Table of Submitter Issues: Stages 1A and 2, Site 43/44, Australia Ave, Sydney Olympic Park

Submitter	Submission – Key Issues	Response	Action
SYDNEY OLYMPIC PARK AUTHORITY 6 September 2013	<p>Water Management The proposal includes sand filtration and gross pollutant traps within the car parks to treat stormwater before it is discharged from the site. This equipment will require on-going maintenance/cleanout. The proponent must provide and implement a management and maintenance regime for the gross pollutant traps consistent with the manufacturer's requirements.</p> <p>Proposed Condition of Consent 1. Prior to the issuing of any Occupation Certificate the proponent must establish an operation and maintenance plan for all water sensitive urban design assets, including gross pollutant traps, for the life of the asset. The plan must include routine checking, cleaning and servicing of all devices in accordance with the manufacturers recommendations and evidence of a maintenance contract covering at least the first two year period. A copy of the maintenance plan and contract must be provided to the Sydney Olympic Park Authority.</p> <p>2. The final stormwater management plan is to be sub

BASEMENT LEVEL 1

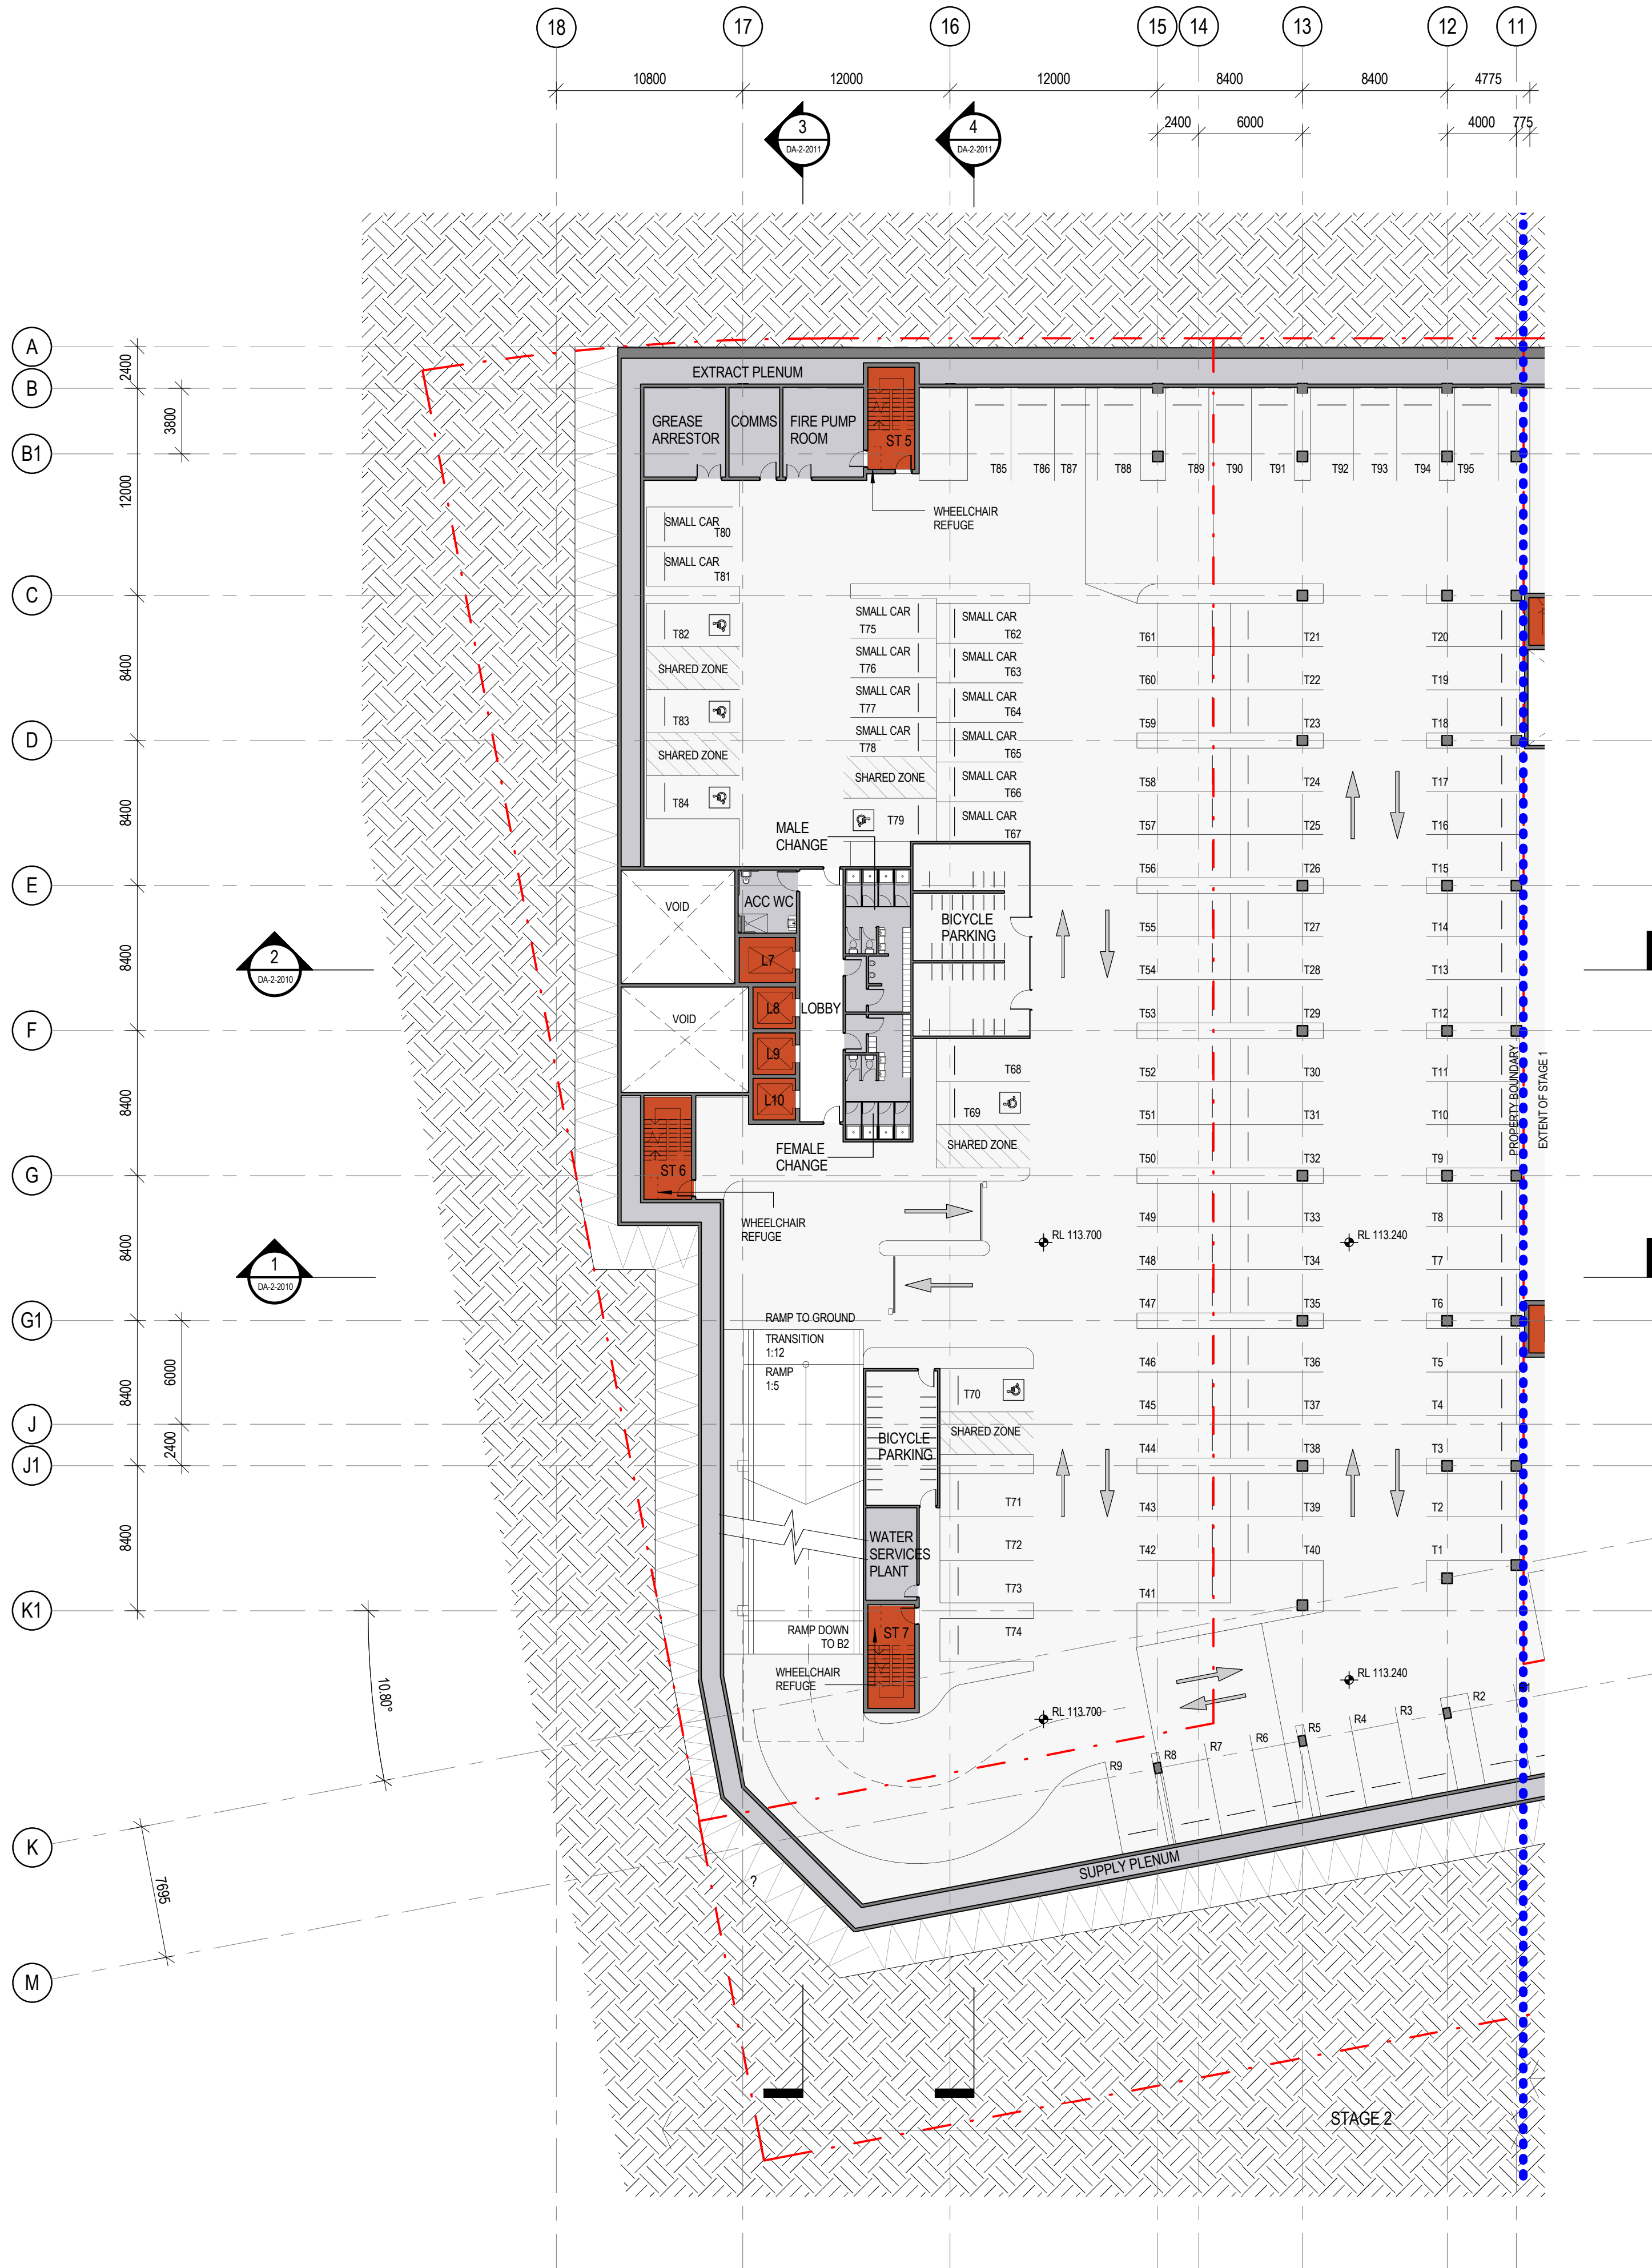
COLONIAL FIRST STATE GLOBAL ASSET MANAGEMENT COMPANY			
	<p>The permissible car spaces on the site are 522 spaces. The allocation by stage is:</p> <ul style="list-style-type: none"> • Stage 1: 280 spaces; and • Stage 2: 299 spaces. <p>Car spaces for Stages 1, 1A and 2 developments combined is 579.</p> <p>The proposal for Stages 1, 1A and 2 developments request the approval of 57 spaces above the site control allowance of 522 spaces.</p> <p>The Stage 2 car spaces should be limited to 242 spaces in compliance with the relevant controls for the subject site, resulting</p>	<p>Within the SSD applications, a total of 504 car spaces over the whole site was proposed, which was less than the maximum of 525 permitted for the site.</p> <p>Following further detailed design of the proposed developments, a discrepancy has been picked up in the total number of car parking spaces provided. There will be a total of 501 parking spaces provided over the whole of the site, not 504 as stated in the EIS.</p> <p>Attachment C – Response to Transport for NSW (TfNSW) & SOPA comments: Stages 1A and 2 addresses this slight reduction in parking numbers.</p> <p>It is unclear how the figures in the submission have been derived, however they are incorrect.</p>	None

Submitter	Submission – Key Issues	Response	Action
	in 522 car spaces across the stages.
